REFUSAL OF PLANNING PERMISSION

APPLICATION NO: 3/2022/0667

DEVELOPMENT PROPOSED: New detached bungalow at the rear of the dwelling. Resubmission of 3/2021/1283.

AT: 2 Bushburn Drive Langho BB6 8EZ

PROPOSED FIRST FLOOR

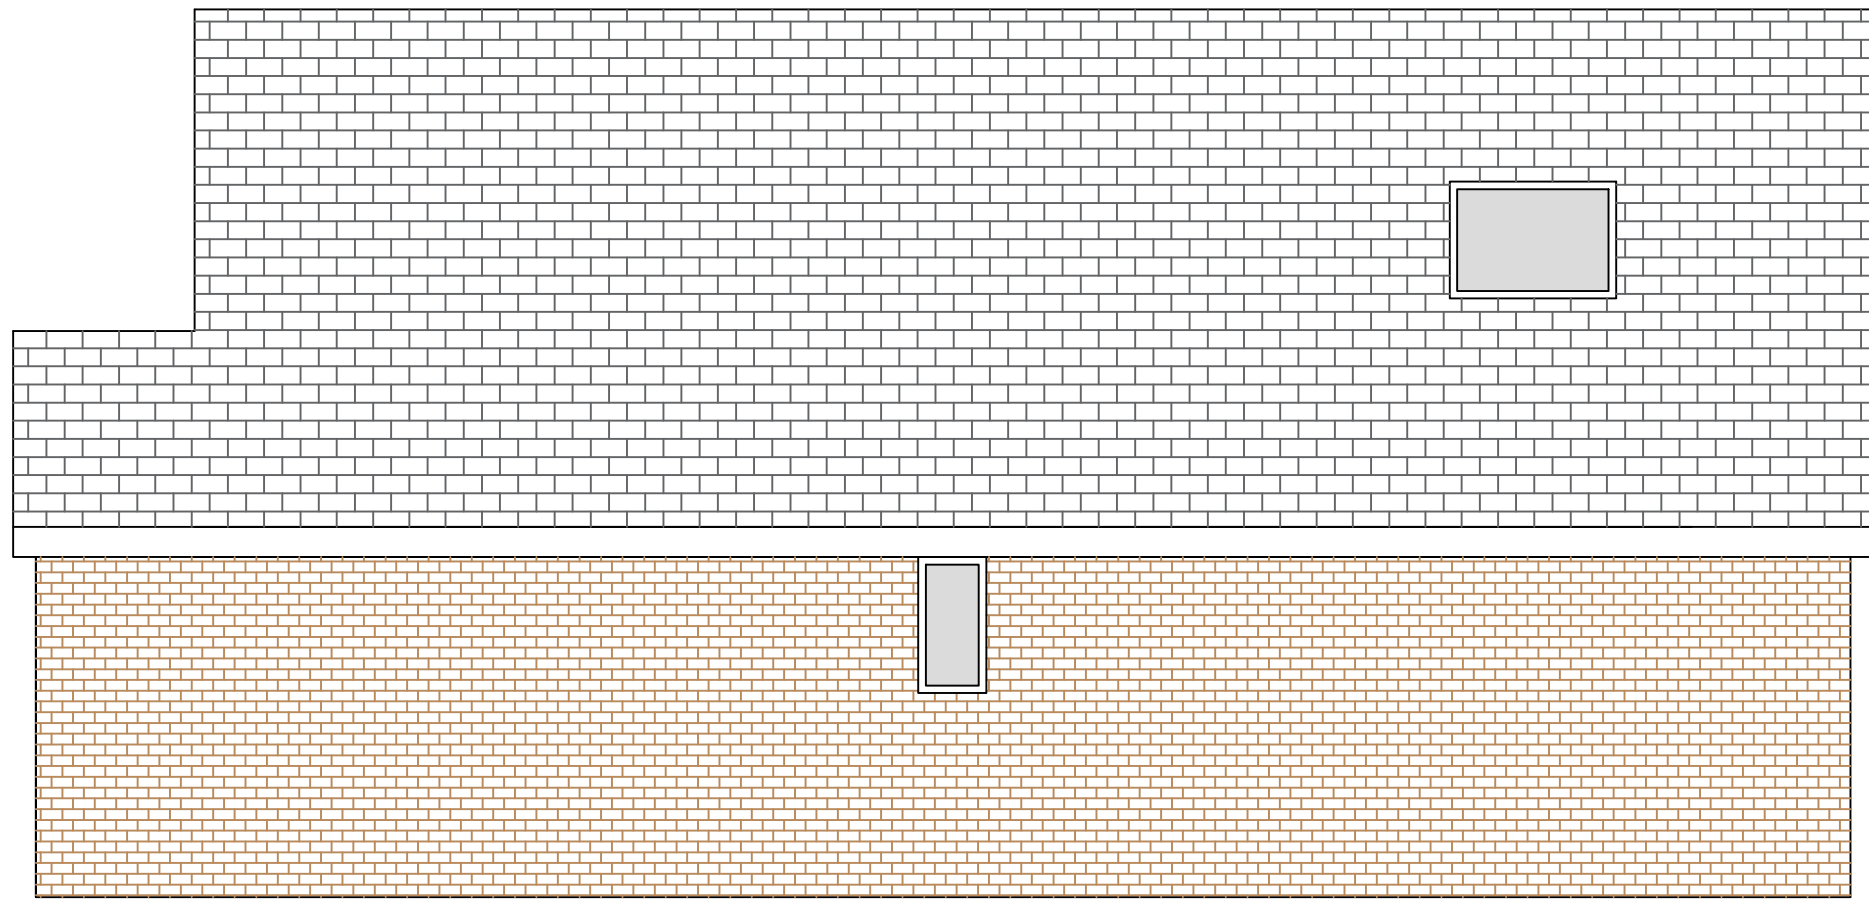
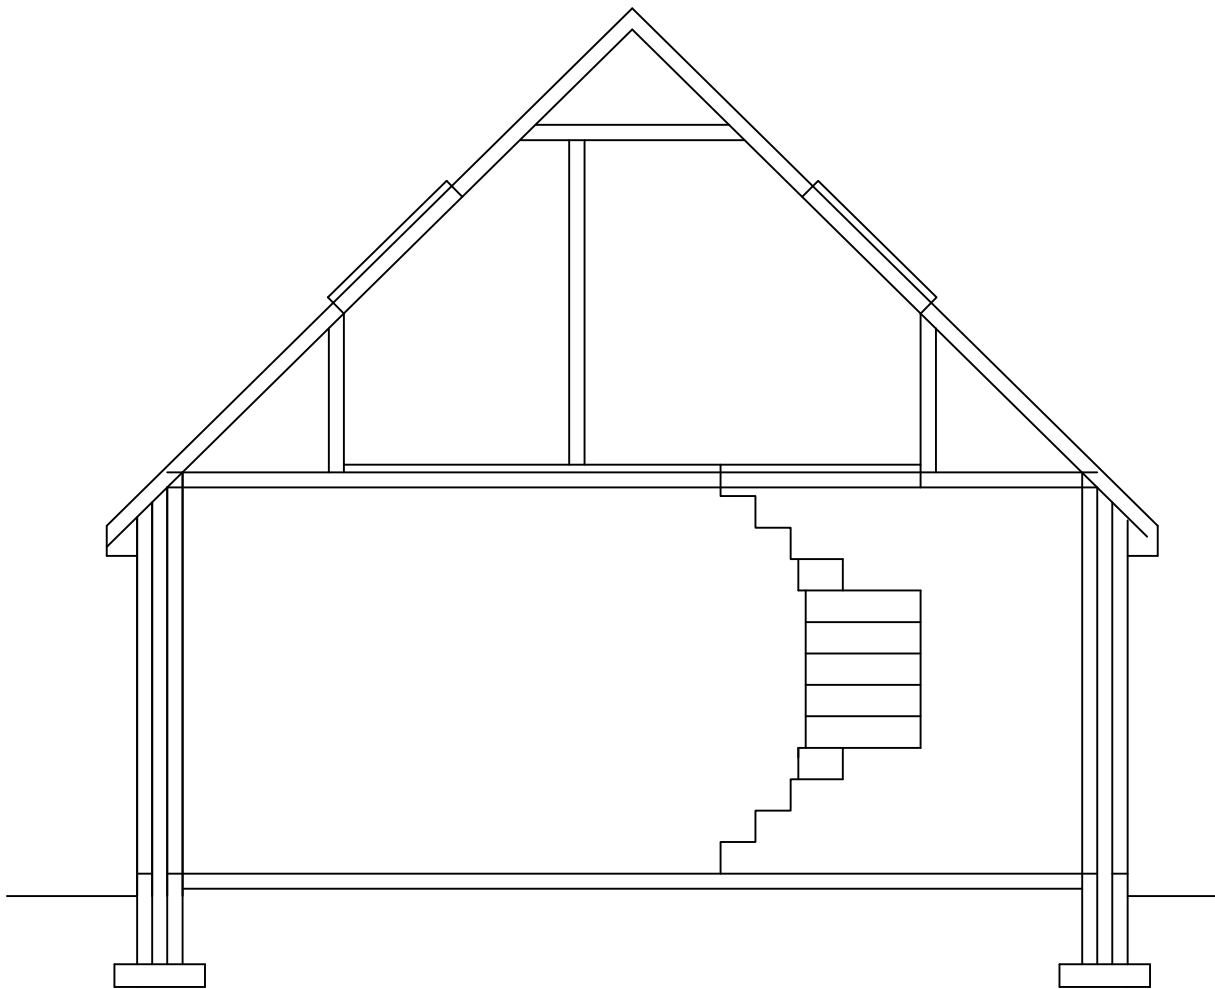
It is further considered that the proposed outlook from the rooflight windows at first-floor (bedroom) would also significantly undermine the residential amenities of numbers 2 and 4 Bushburn Drive and that of 29 Moorland Road by virtue of direct overlooking of private garden areas from an elevated position. As such the proposal is considered to be in significant direct conflict with the aims and objectives of Policy DMG1 of the Ribble Valley Core Strategy.

Proposed Site Plan

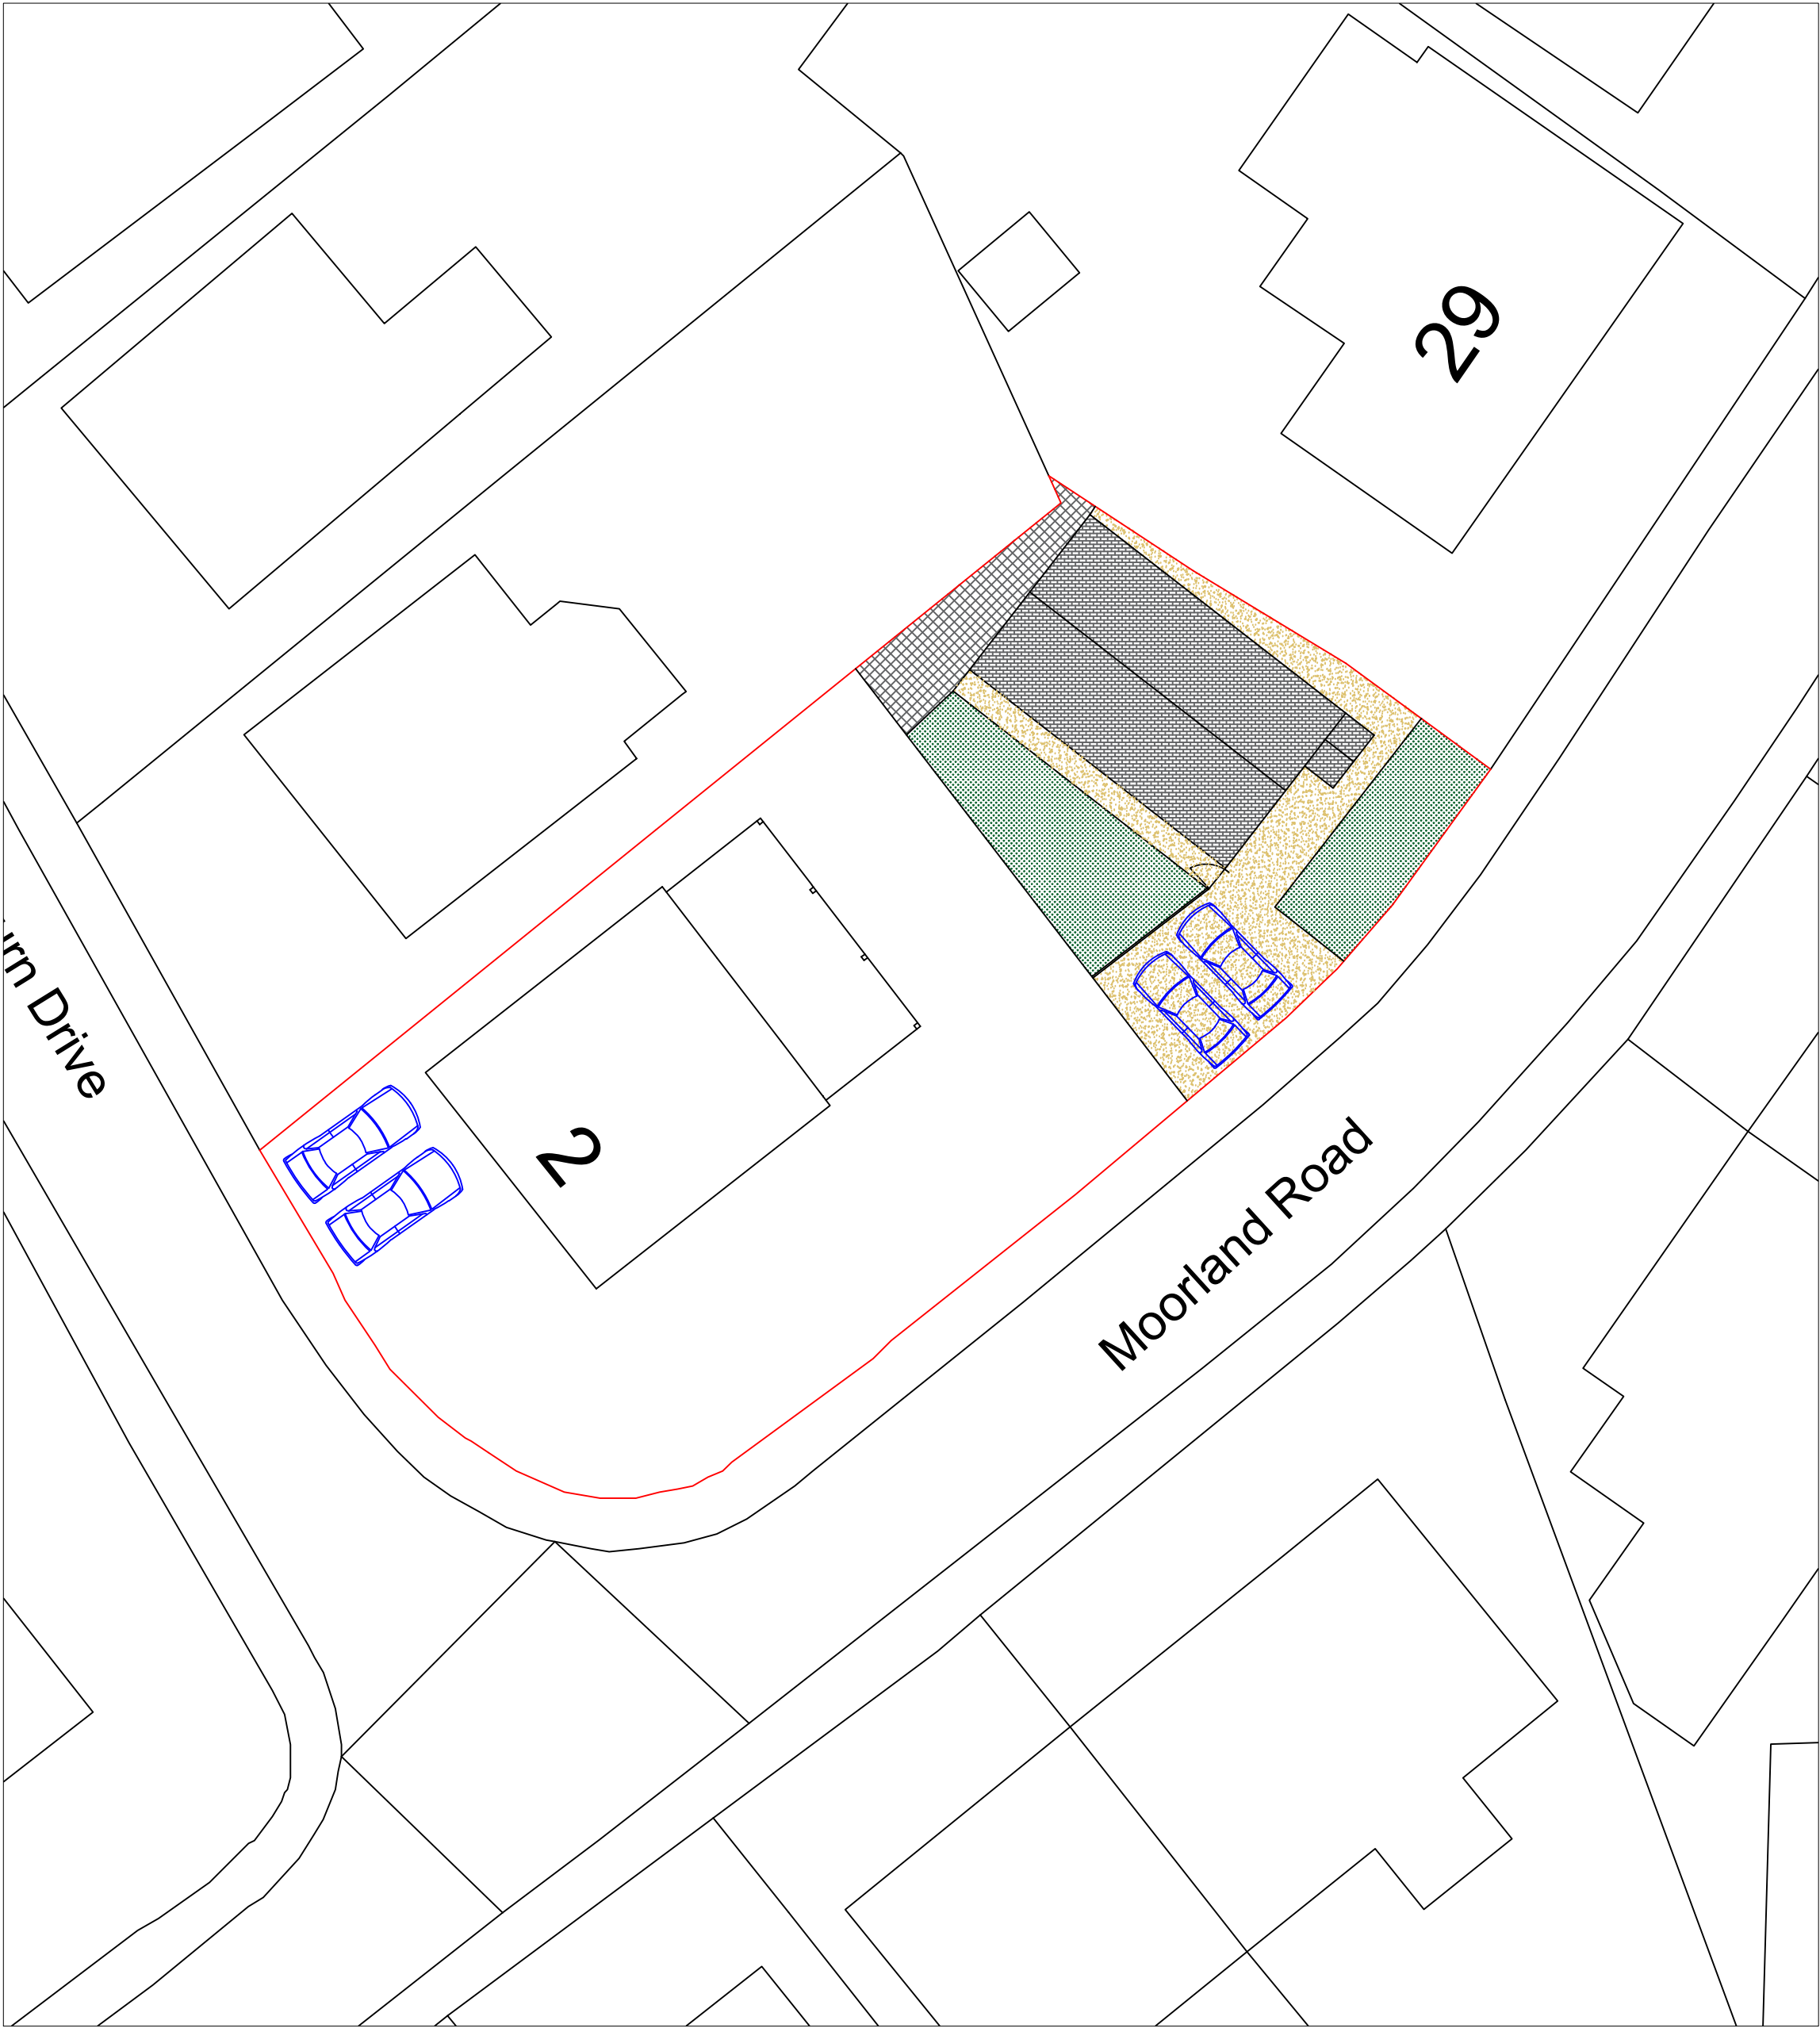
- 1 The proposal is considered contrary to Policy DMG1 of the Ribble Valley Core Strategy Paragraphs 130 and 134 of the National Planning Policy Framework insofar that approval of the proposal would result in the introduction of an anomalous, discordant and cramped form of development that fails to respond positively to the inherent pattern and spatial characteristics of development within the locality, being of significant detriment to the character and visual amenities of the area.
- 2 The proposal would significantly undermine the sense of privacy enjoyed by occupiers of number 4 Bushburn Drive by virtue of direct overlooking, within close proximity, from habitable room windows at ground floor, into the private garden area of the affected dwelling.
